Hera Mine MOD 5 – SSD 10_0191

I refer to your email dated 18 March 2019 seeking comments from the Office of Environment and Heritage (OEH) on the Environmental Impact Statement (EIS) for the proposed Hera Gold Mine Mod 5.

OEH review of Hera Gold Mine Mod 5 EIS

Figure 9-1: Proposed Biodiversity Stewardship Site (Source BMP 2016)

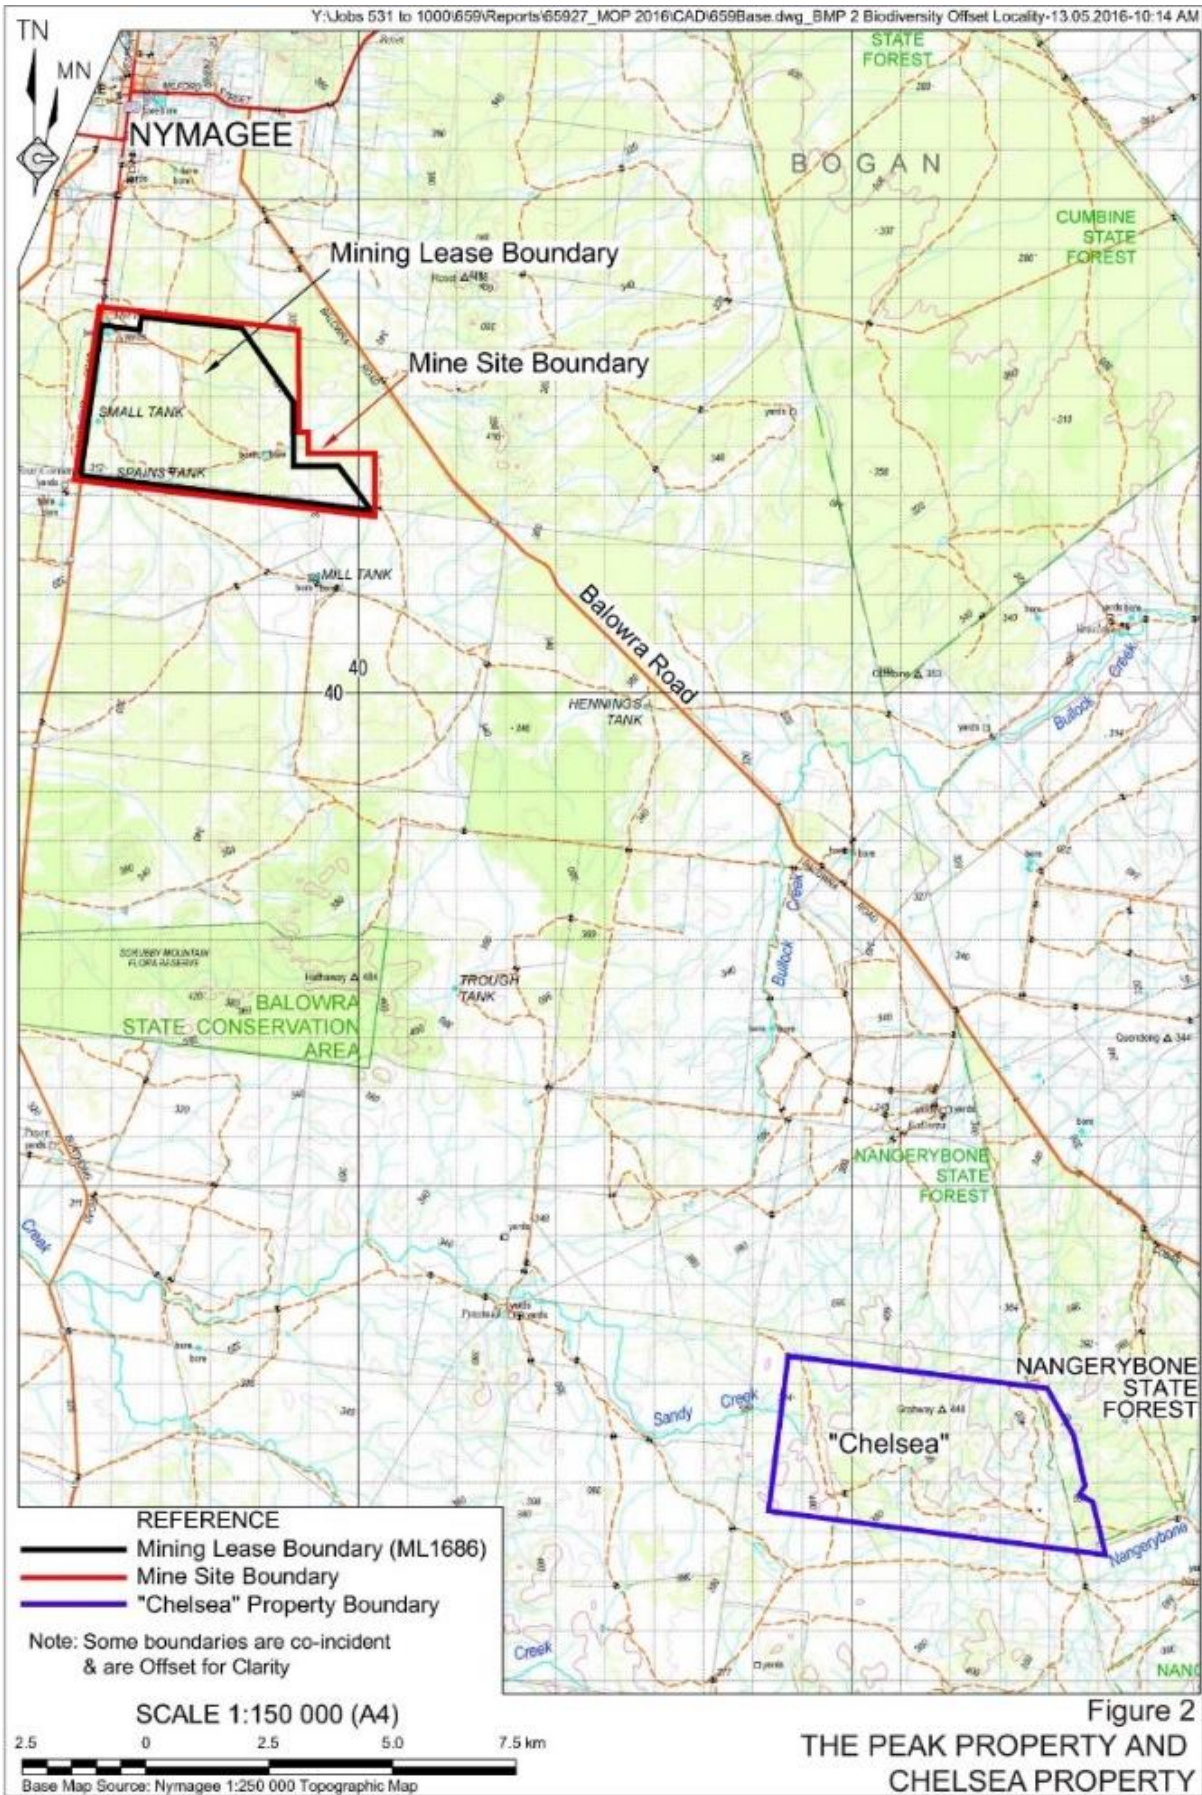
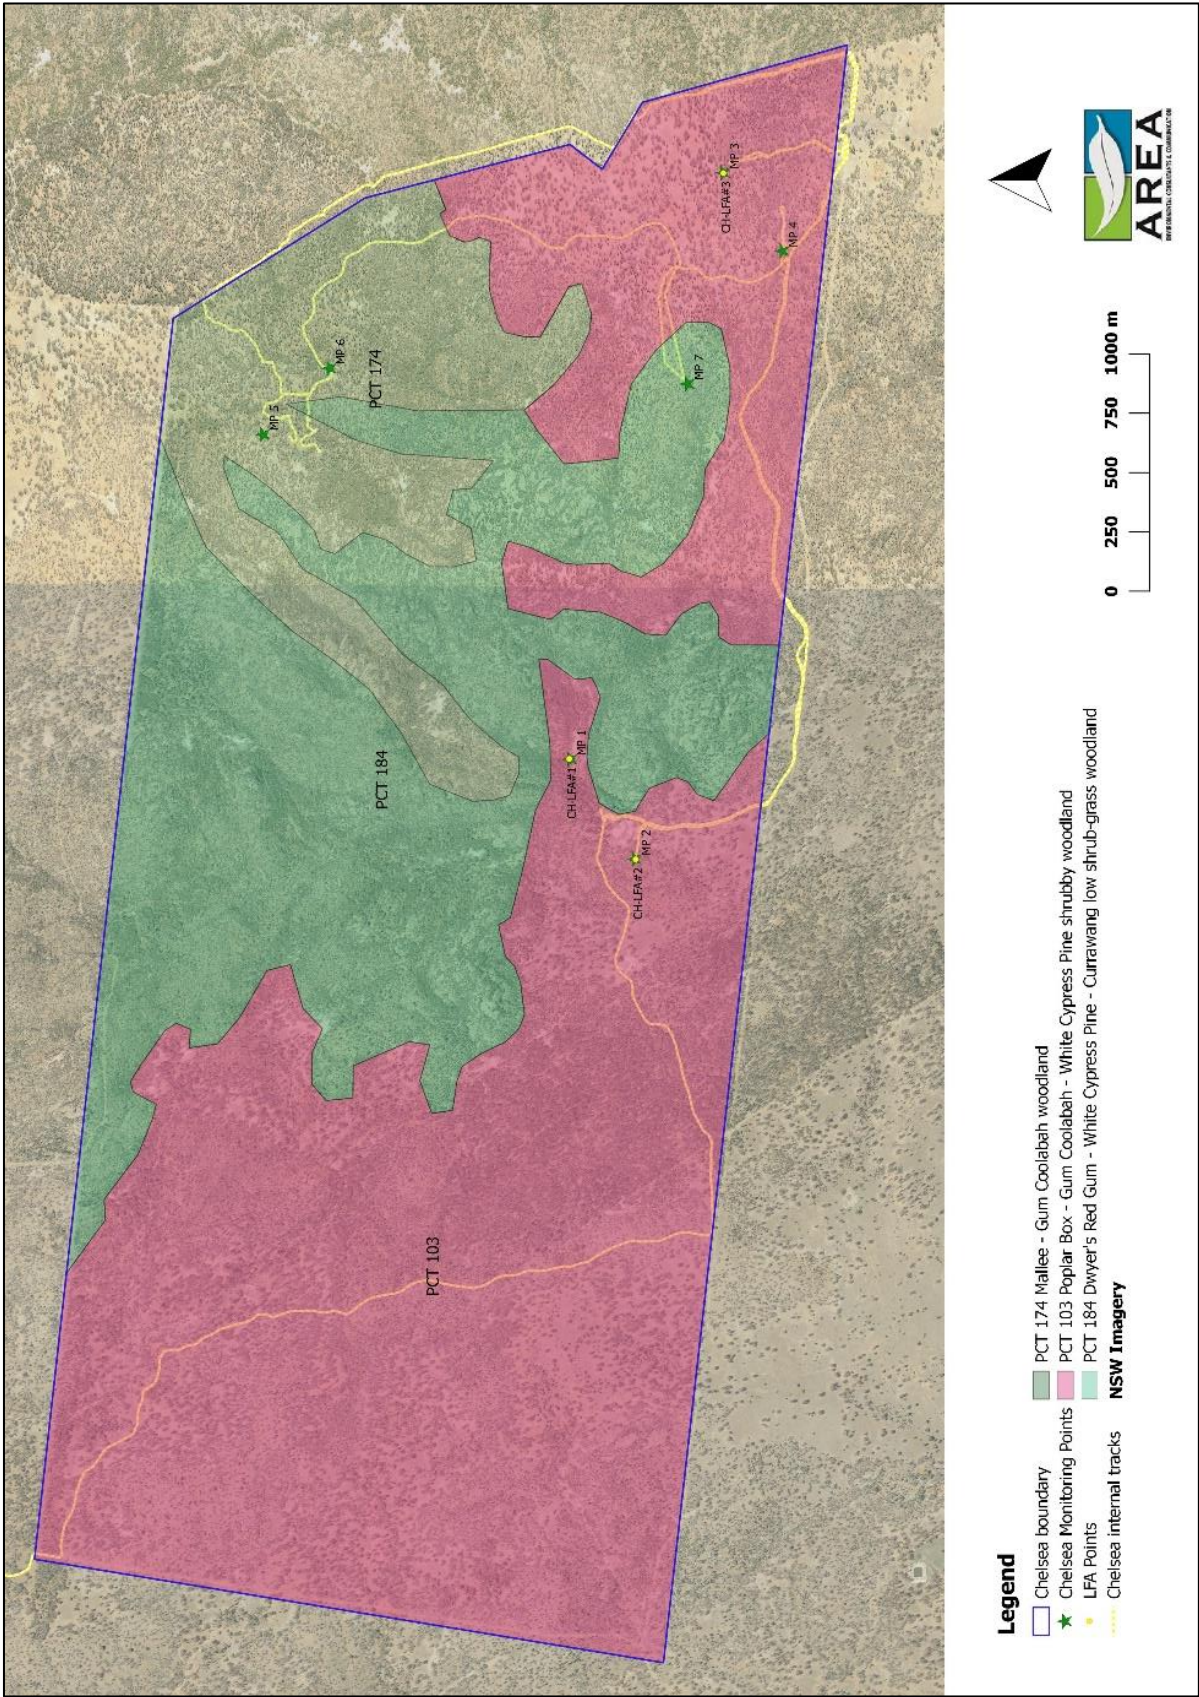
Table 9-3 provides the offsetting options for MOD 5 as well as previous Hera Mine developments. OEH notes that these previous offsetting commitments have yet to be realised as the proposed Chelsea BioBanking Site has yet to be finalised. The BDAR indicates that the proponent is in the process of commissioning a Biodiversity Stewardship Site Assessment Report (BSSAR) to establish a Biodiversity Stewardship Site on 'Chelsea'.

The credits in Table 9-3 are a mix of BioBanking and BAM credits. The BDAR correctly states that the BioBanking credits will need to be converted to BAM credits and that there can be no certainty that there are enough credits to retire the MOD 5 credit requirement until this occurs. The BDAR provides the commitment that any residual offsetting requirement will be achieved using other approved mechanisms under the BC Act.
